**RE:** Barelas Park Improvements

**Grading & Drainage Plan**

**Hydrology File: K14D047**

Re: Barelas Park Improvements G&D Comments

| 615792                  | K-13 & K-14            | C-104              |             |             |

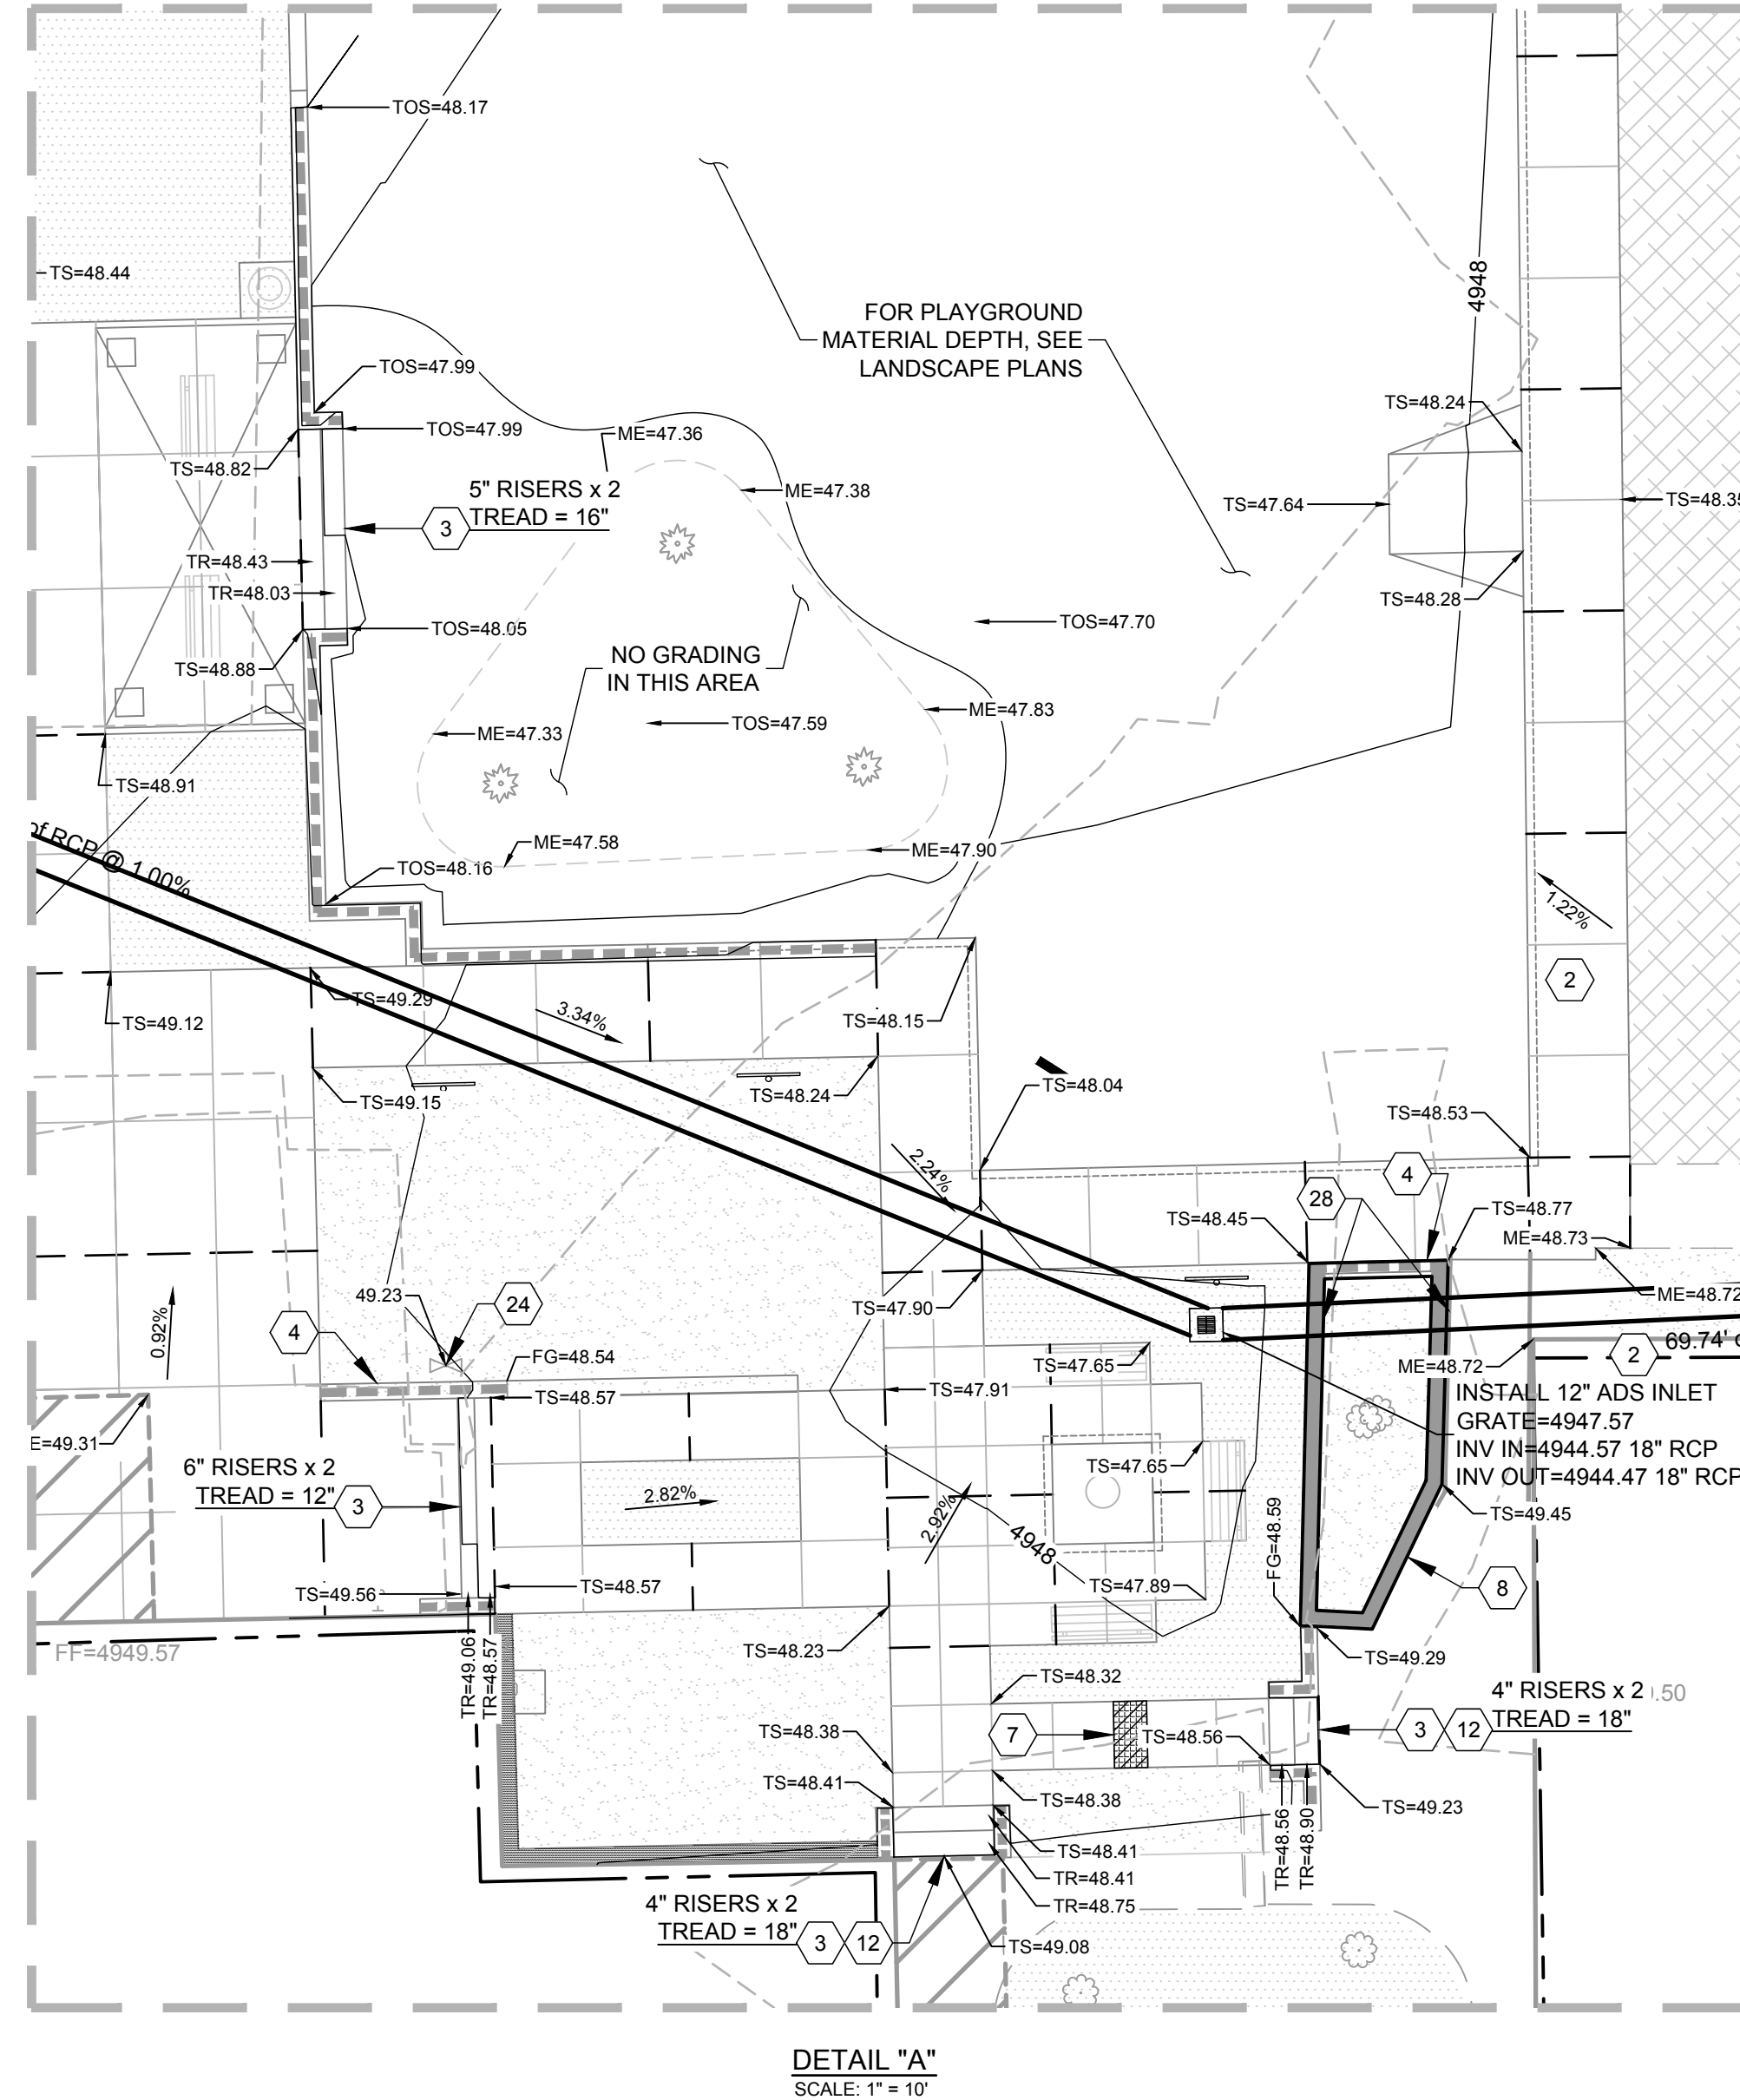
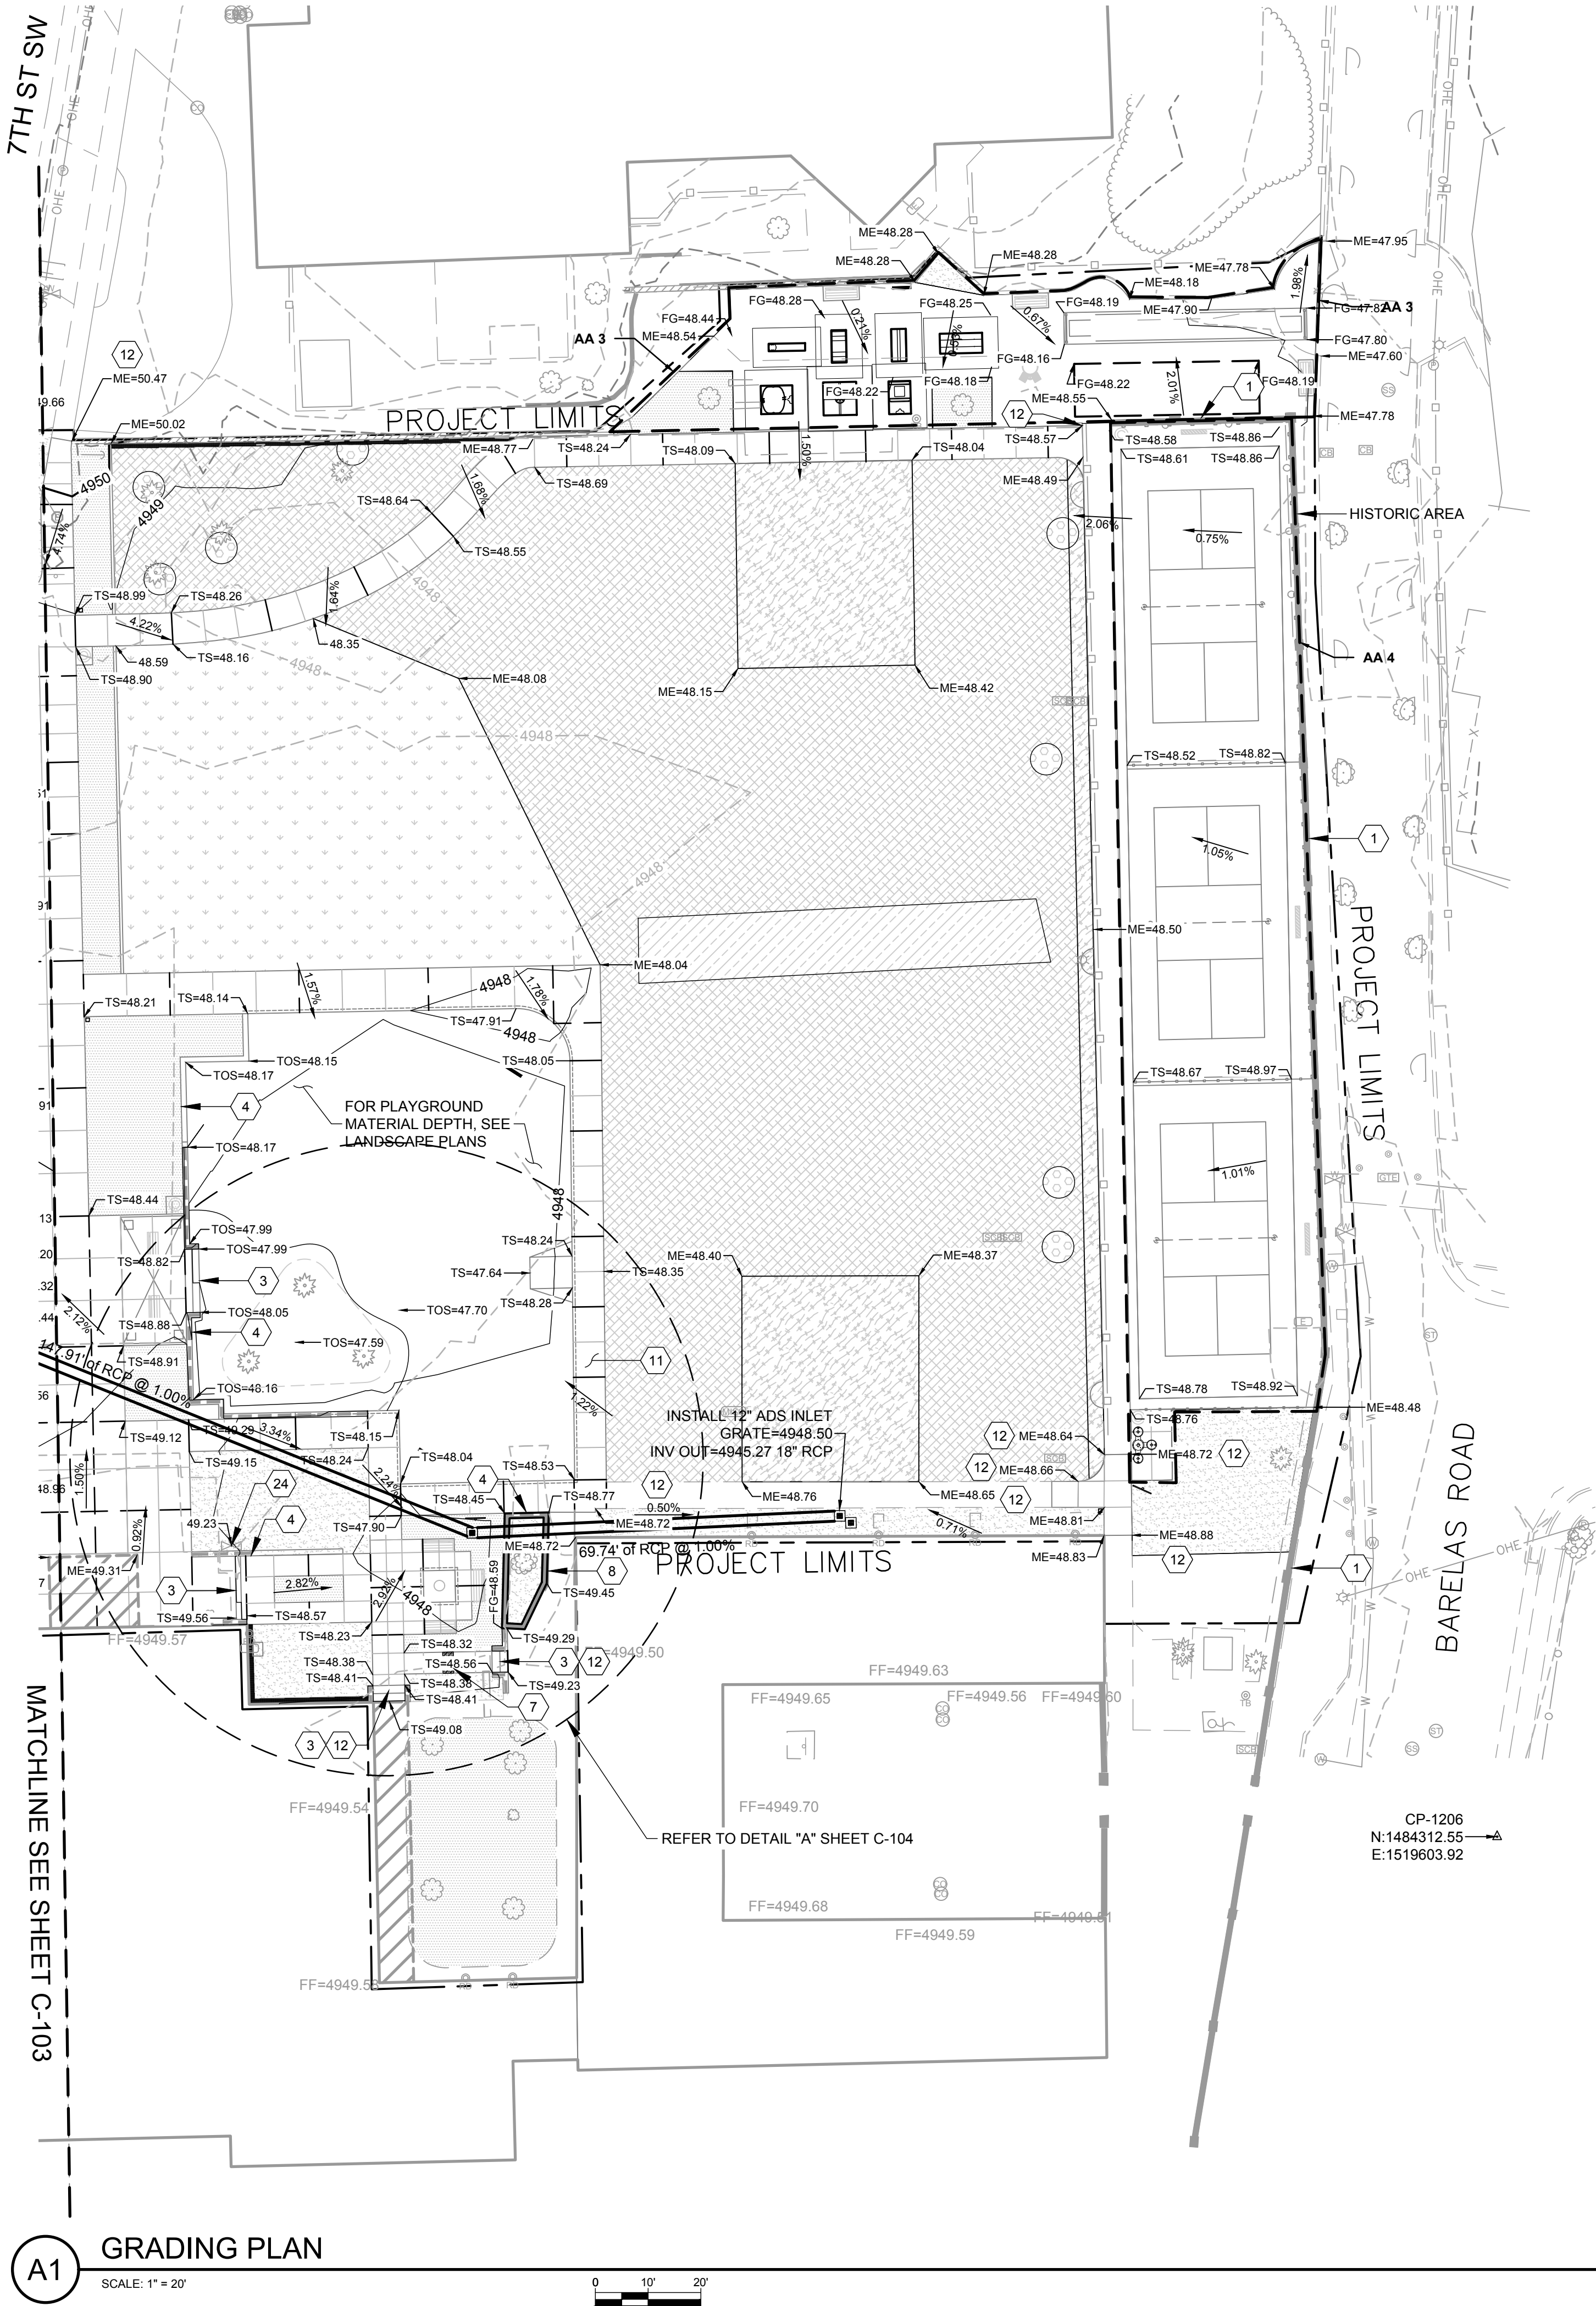
Instead of boring an 18-in RCP under the existing raised planter, wouldn't be better to just add another inlet and route the new pipe as shown? Something to think about.

The area north of sidewalk is a playground, which means there will not be enough cover for the describe pipe.
